| Application number: 2026/91912   |                                                                                  |
| What is the application for?:    | Removal/variation of conditions 2 and 3 (plans) on previous permission 2023/9296 |
| Address of the site or building: | rear of, 271, Cliffe Lane, Gomersal, Cleckheaton, BD19 4SB                       |

Planning Site Layout

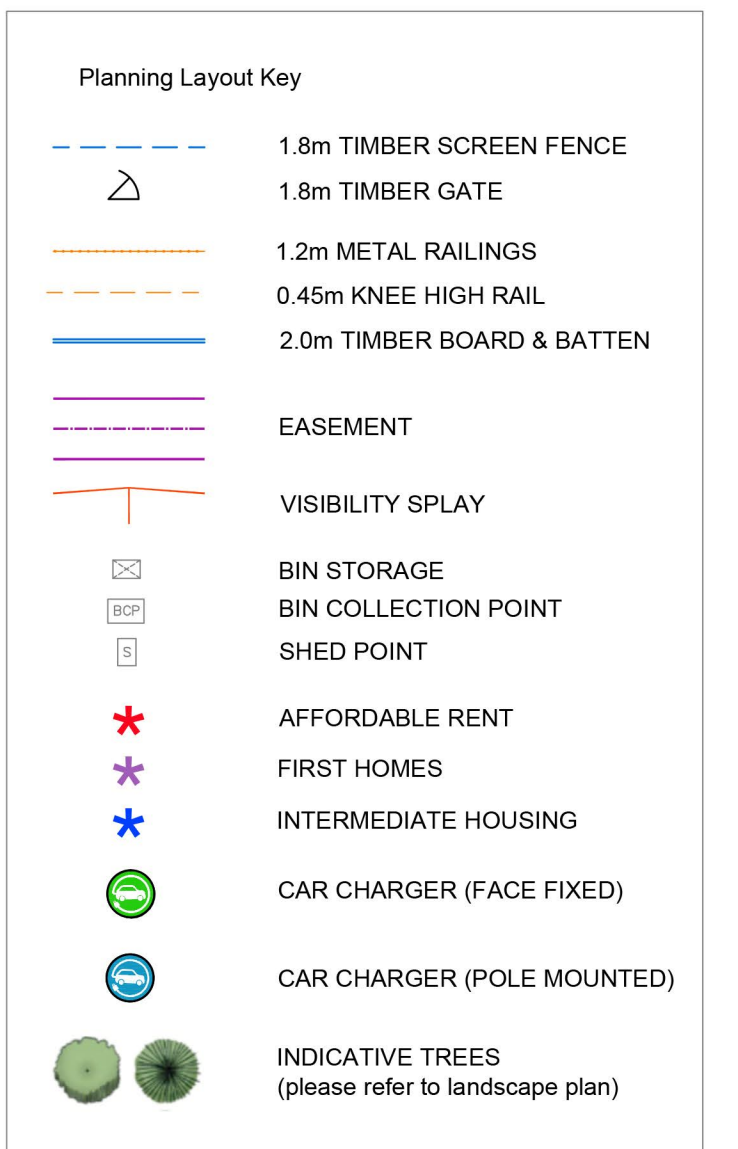
| <p>I object to the development of this land for the follow reason;<br/>It will not increase biodiversity and I have not been shown an up to date environmental impact report.<br/>It will vastly increase the traffic on Cliffe lane which is already very busy.<br/>The plans show the properties very close to my boundary and I will lose privacy.<br/>This is green belt land.<br/>This will completely change the area from rural to an estate.<br/>This development will speed water runoff and increase flooding in Spen beck.</p> |     |
